RESUBMITTED  
11-13-78

932 CHELWOOD PARK BLVD N.E.  
STANDARD REQUIREMENTS FOR DRAINAGE PLANS  
GRANDVIEW HEIGHTS LOT 3 BLK 10

CHERRYWOOD PARK BLVD N.E.
SITE & DRAINAGE PLAN
 LOT #3
 BLK #10
 GRANDVIEW HEIGHTS

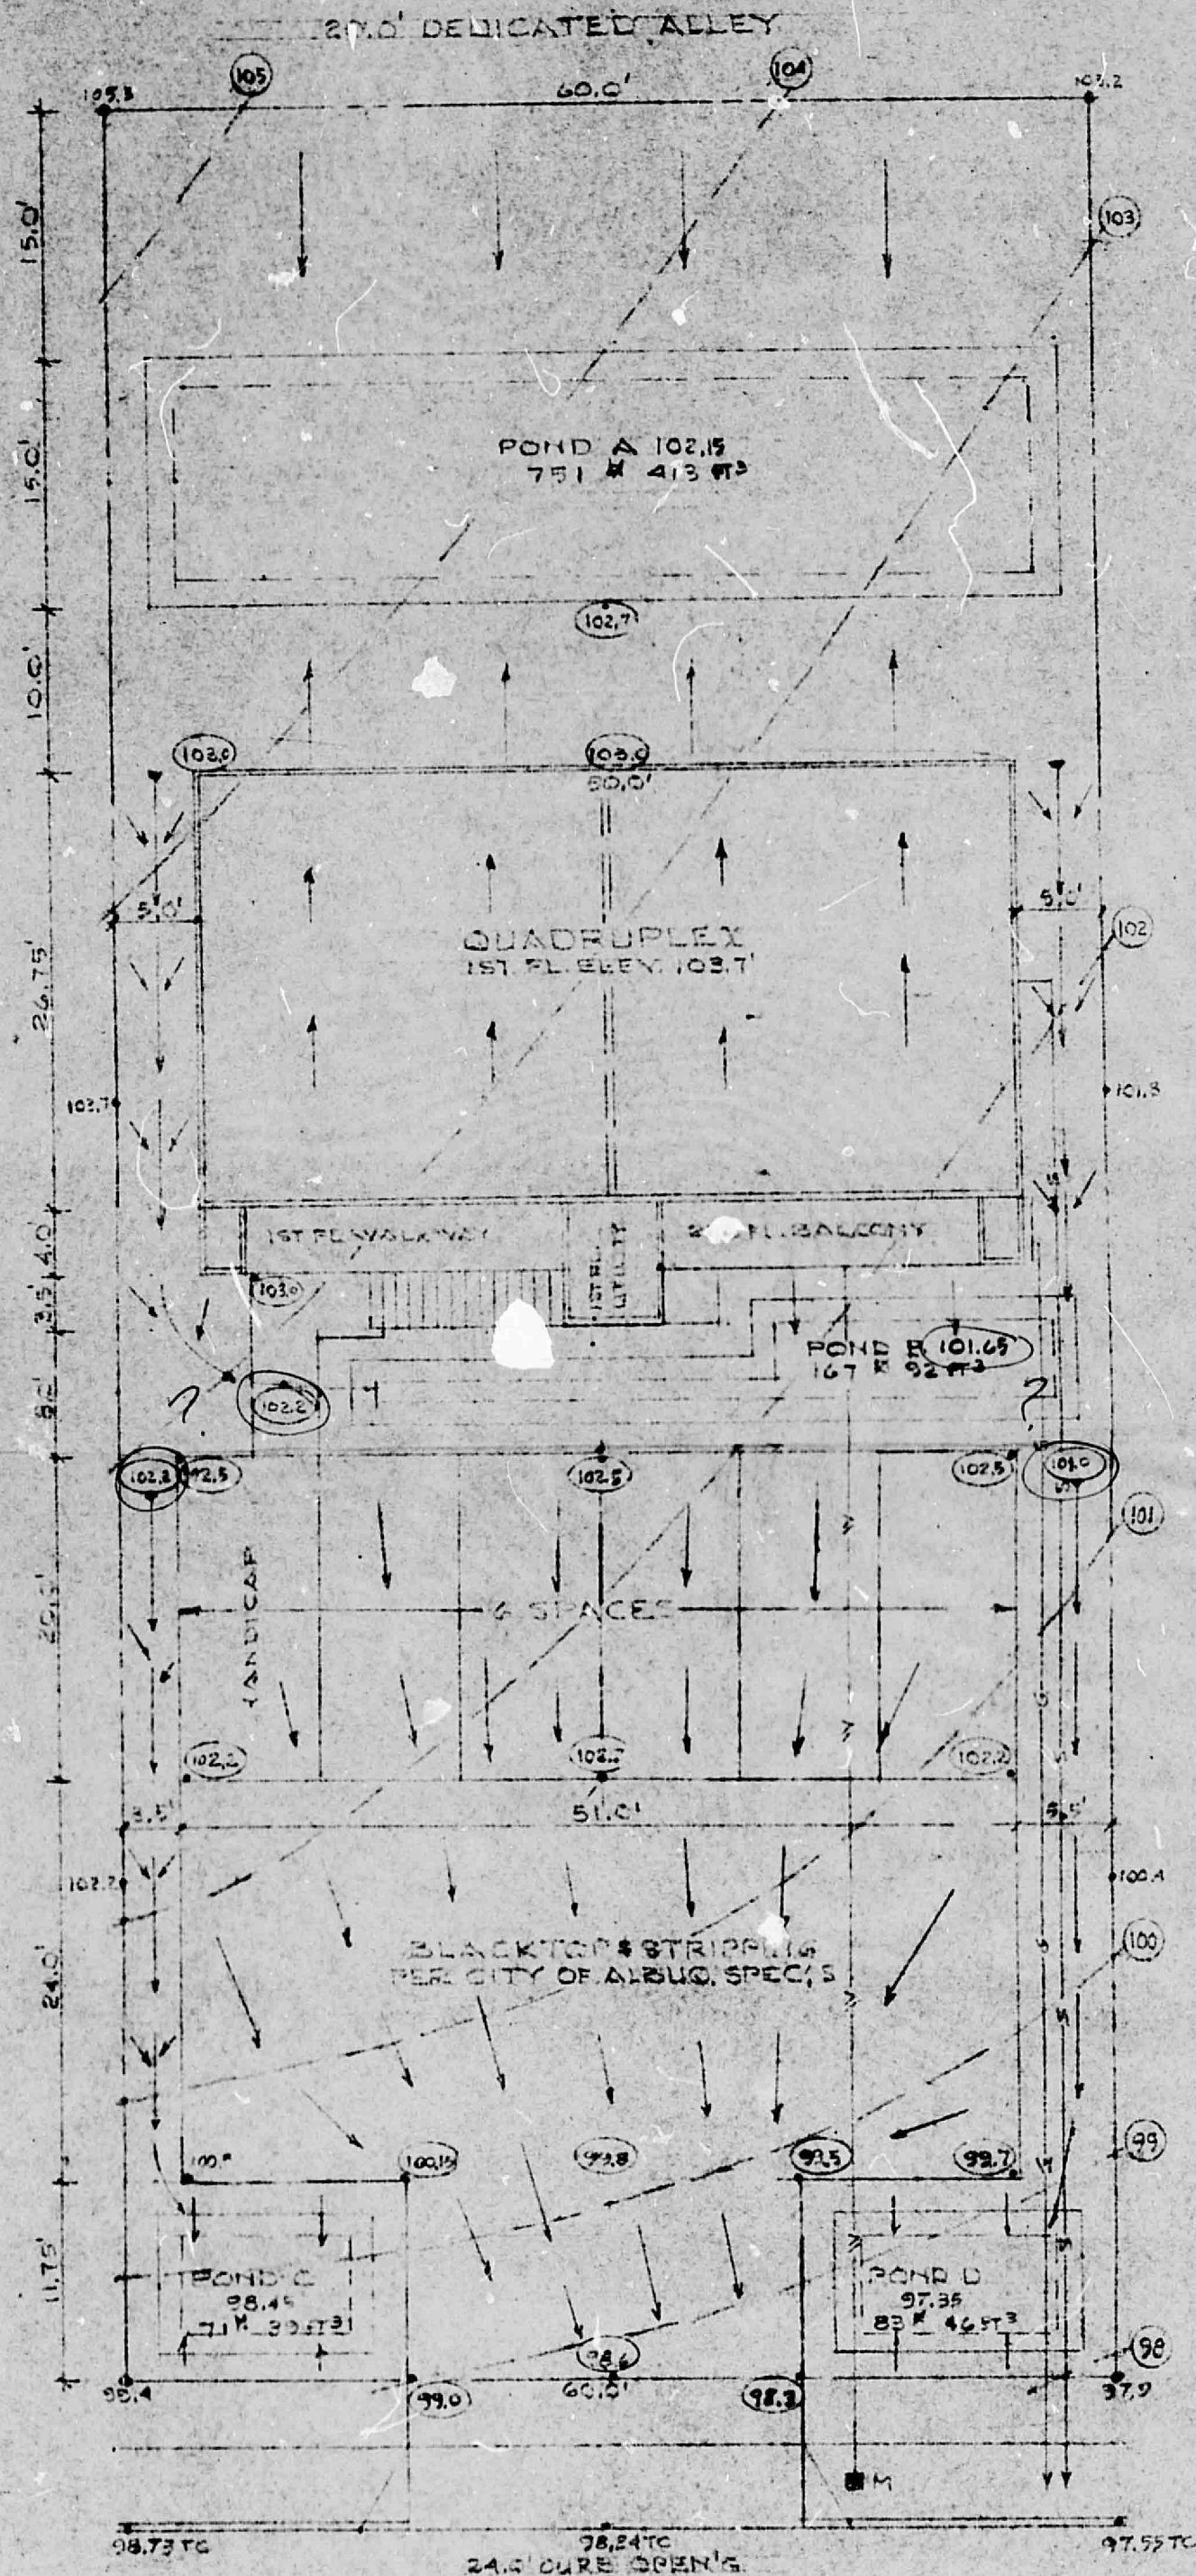
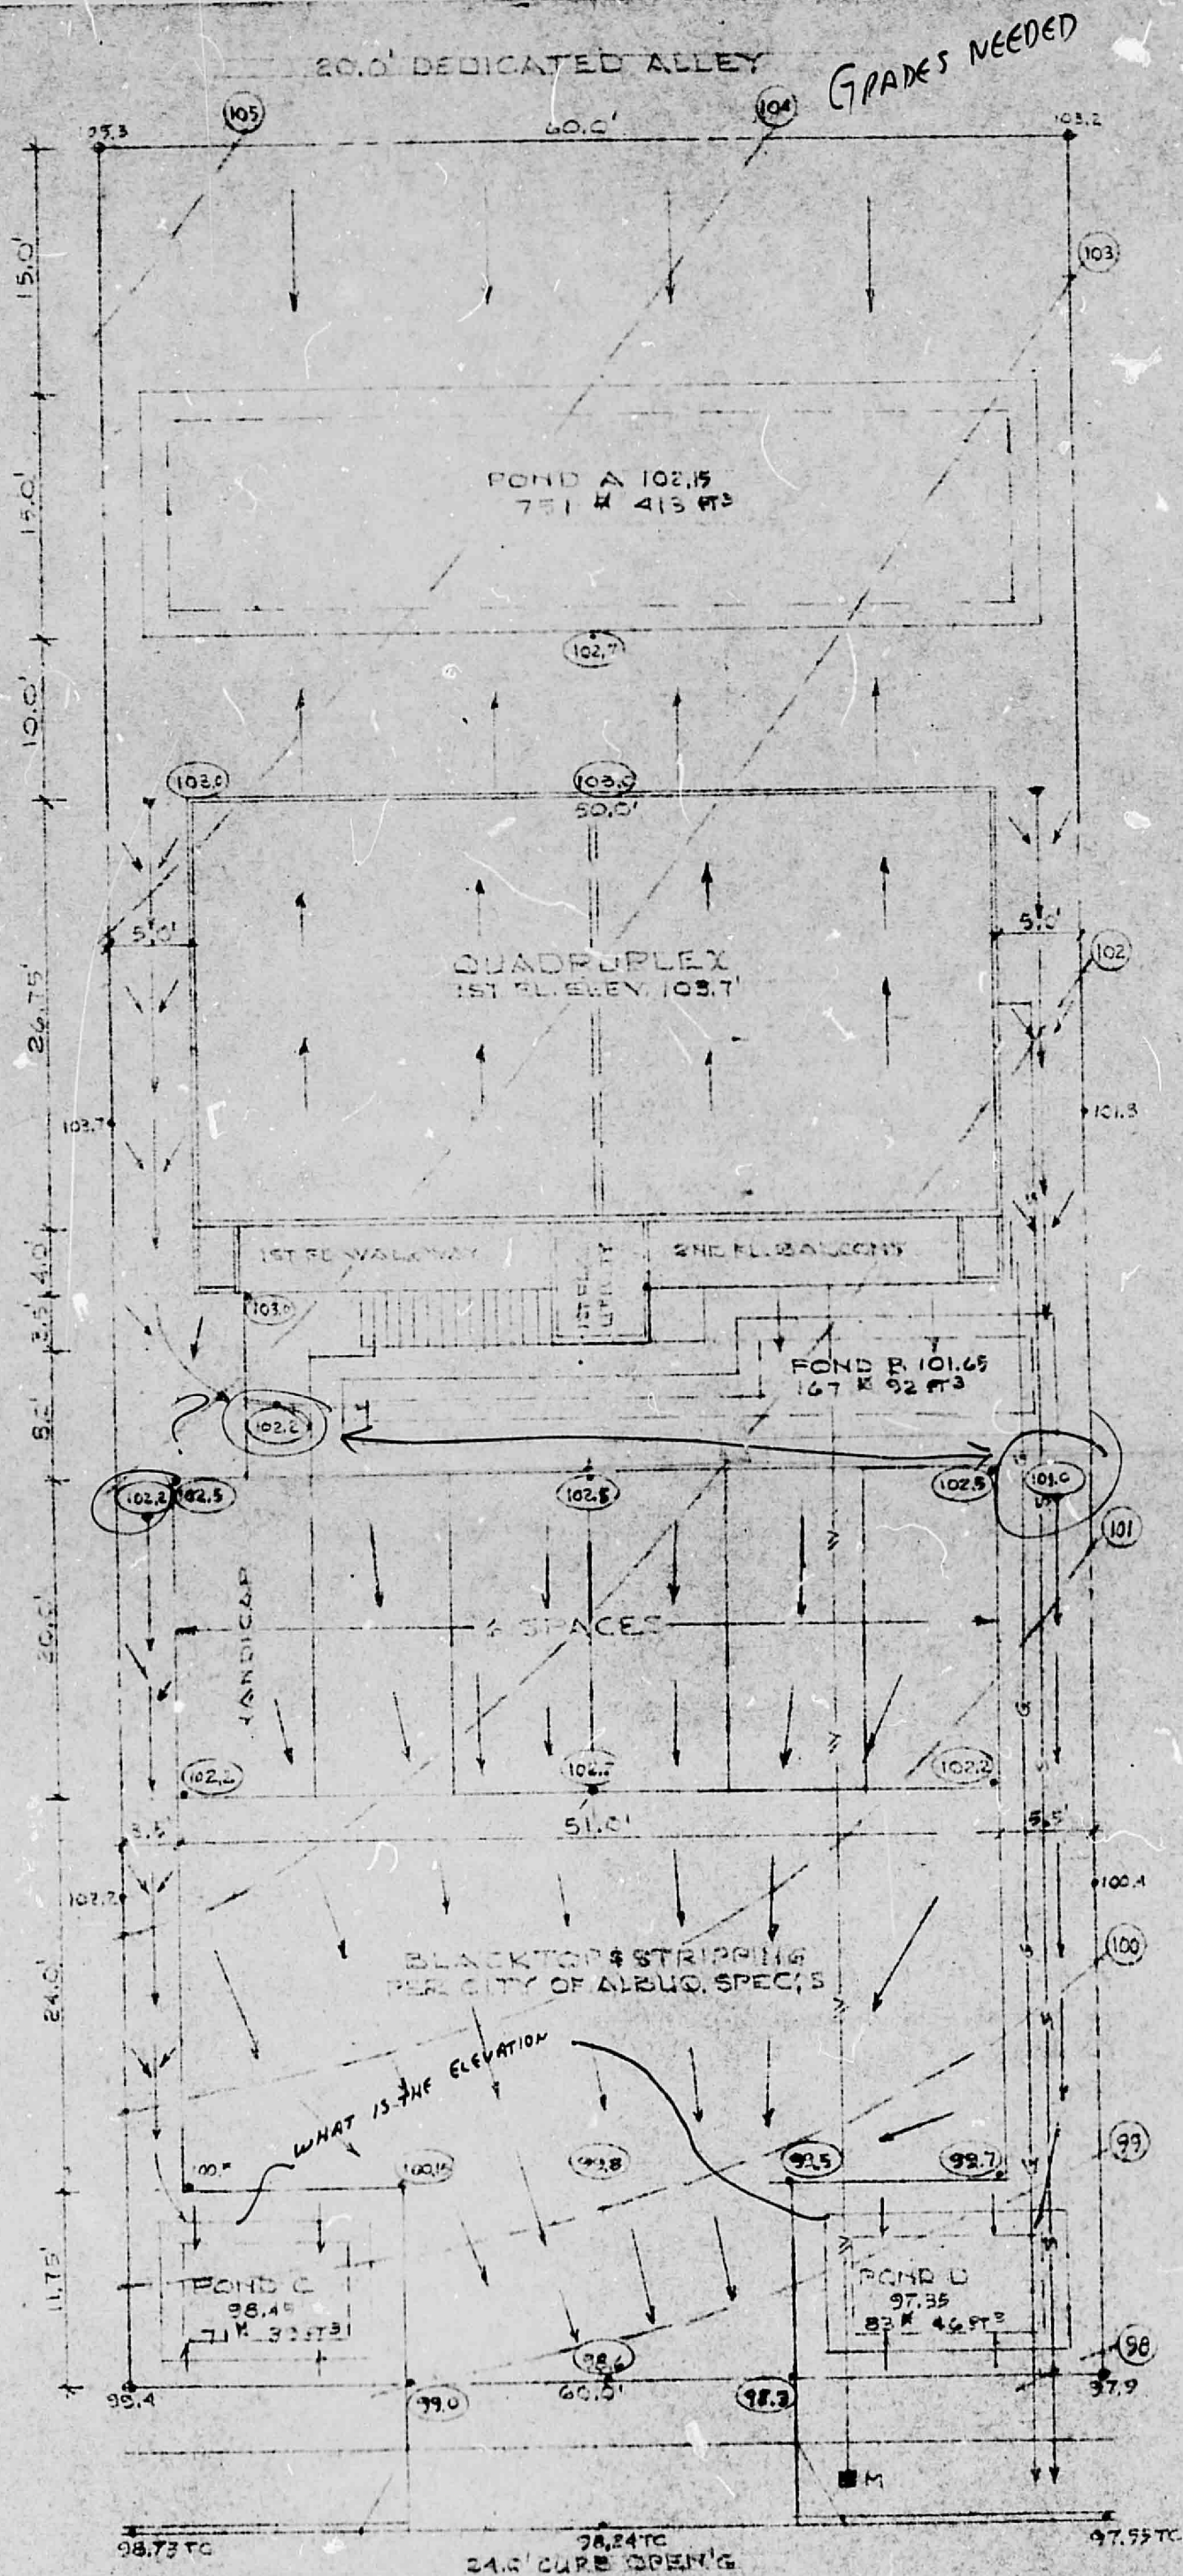
I NEED THE PROPOSED GRADES FOR THE ALLEY.

REQUIRE TWO COPIES OF SITE GRADING PLAN - FOR MY FILES

Is ponding volume adequate (supply detailed computation)? *3:1 SLOPE REQUIRED*

Are ponds balanced with areas they drain (can area draining to each pond be easily identified and will actually water flow there)? The plot plan must outline each drainage area. *SHOW VOLUME DRAINING TO EACH POND*

COULD REDUCE POND DEPTHS. OR ELIMINATE

PONDS C & D

*Approved  
because  
ponding was  
mentioned  
adequately*
